DALSWINTON QUARRY SSD PROJECT – SSD -9094

Response to Request for Information

Dalswinton Quarry

Report 19/047 RFI

EIS Figure 2: History of Site Operations

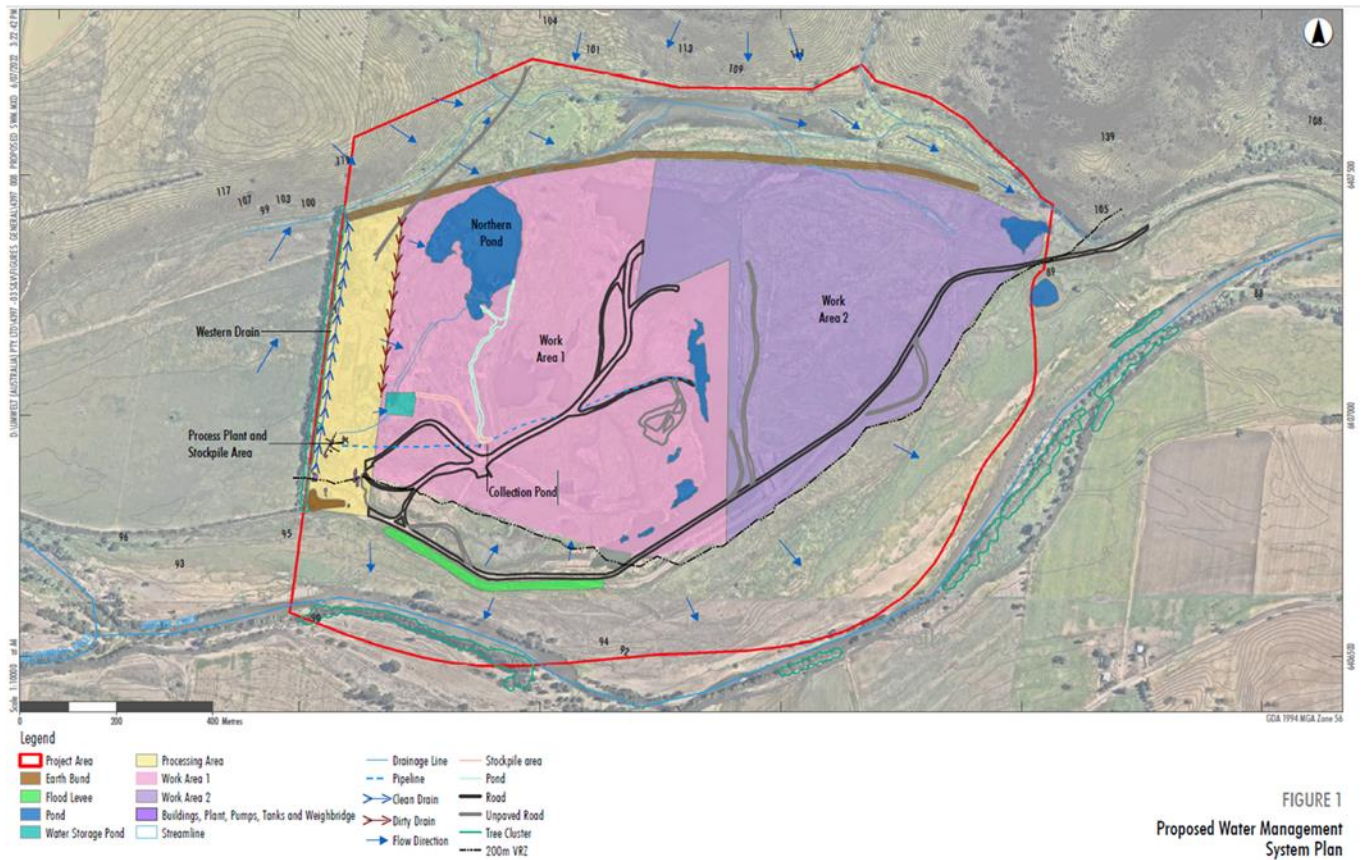
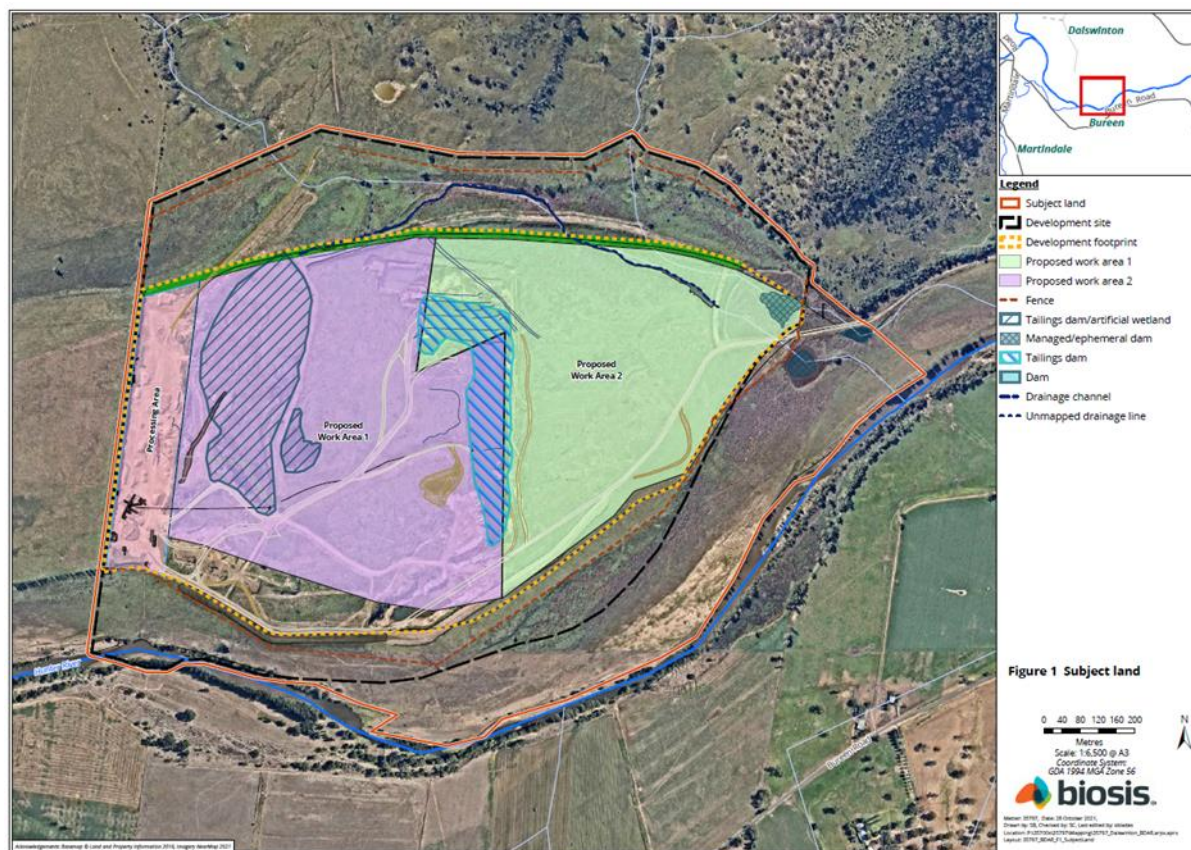
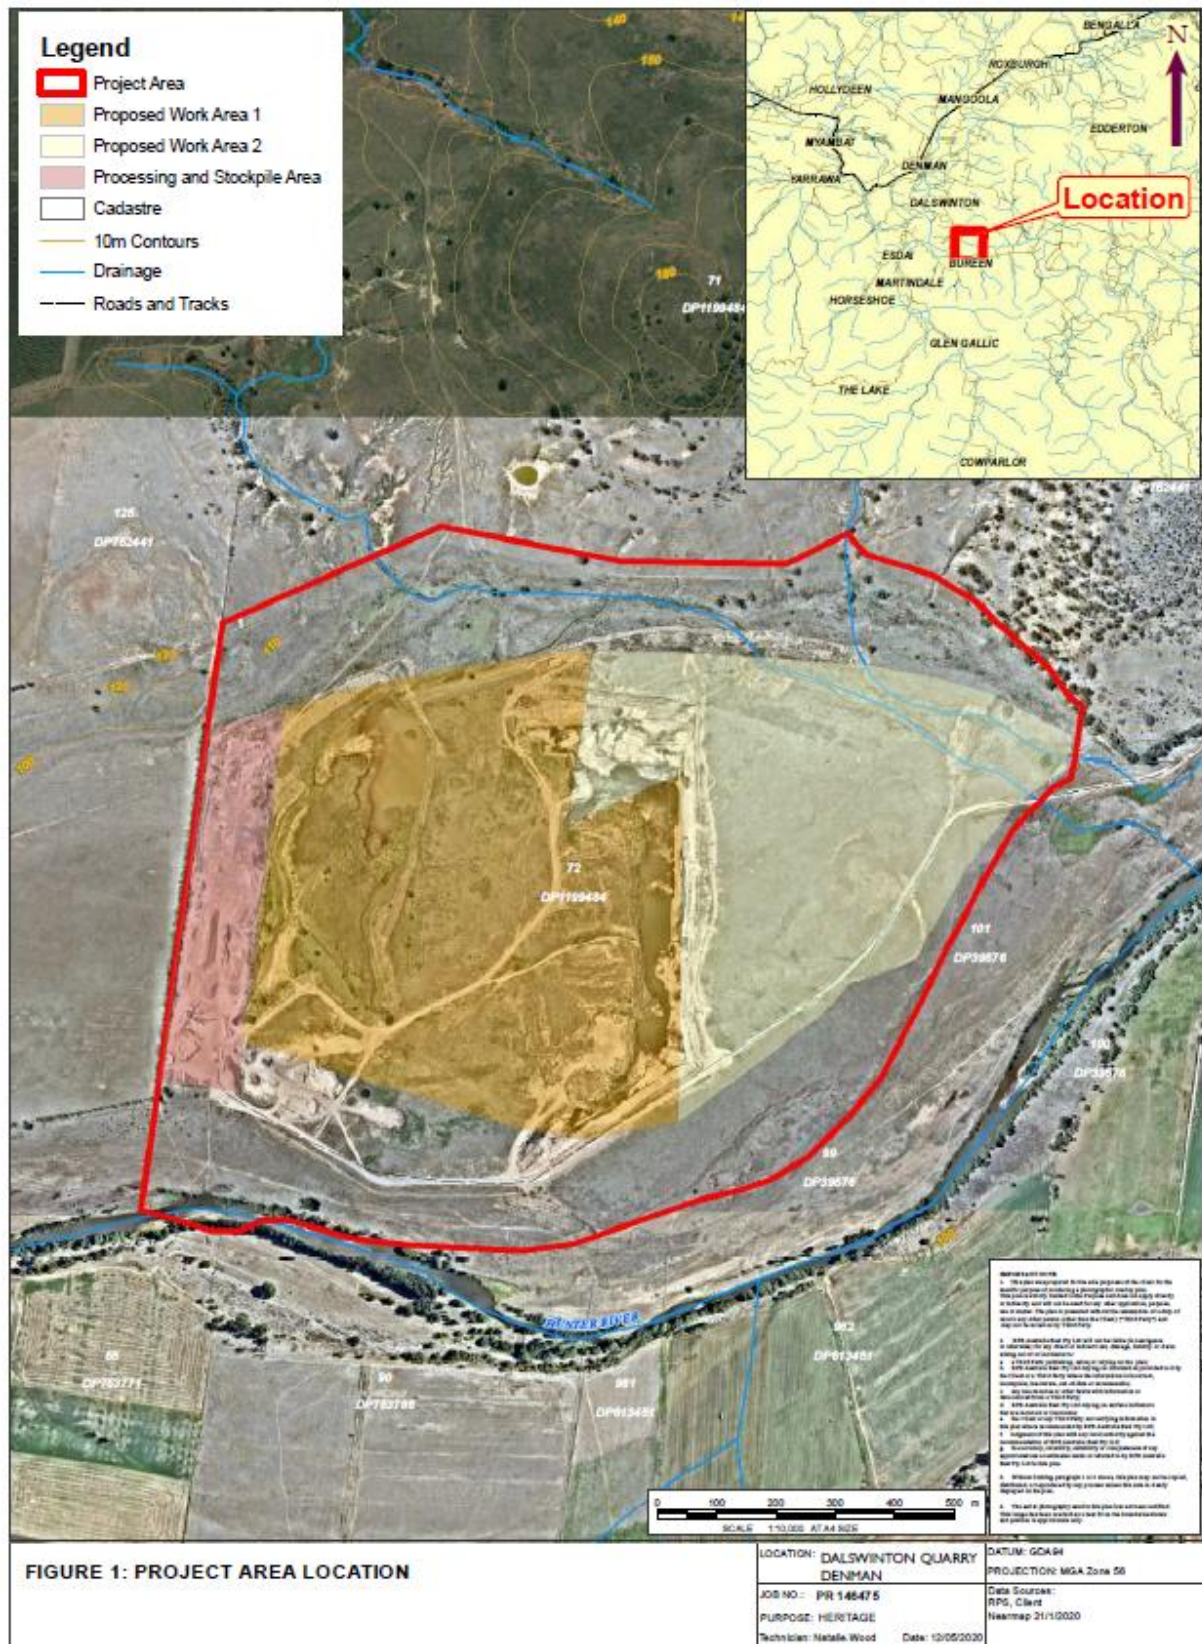
- distance to the closest dwelling (EIS states 600m, RTS states 1.1km).
The closest dwelling to the subject site is 600m towards the southeast of the site.
and
- disturbance boundary and project boundary (see Attachment B).

Project Area – 160 ha

Disturbance Boundary – 89 ha
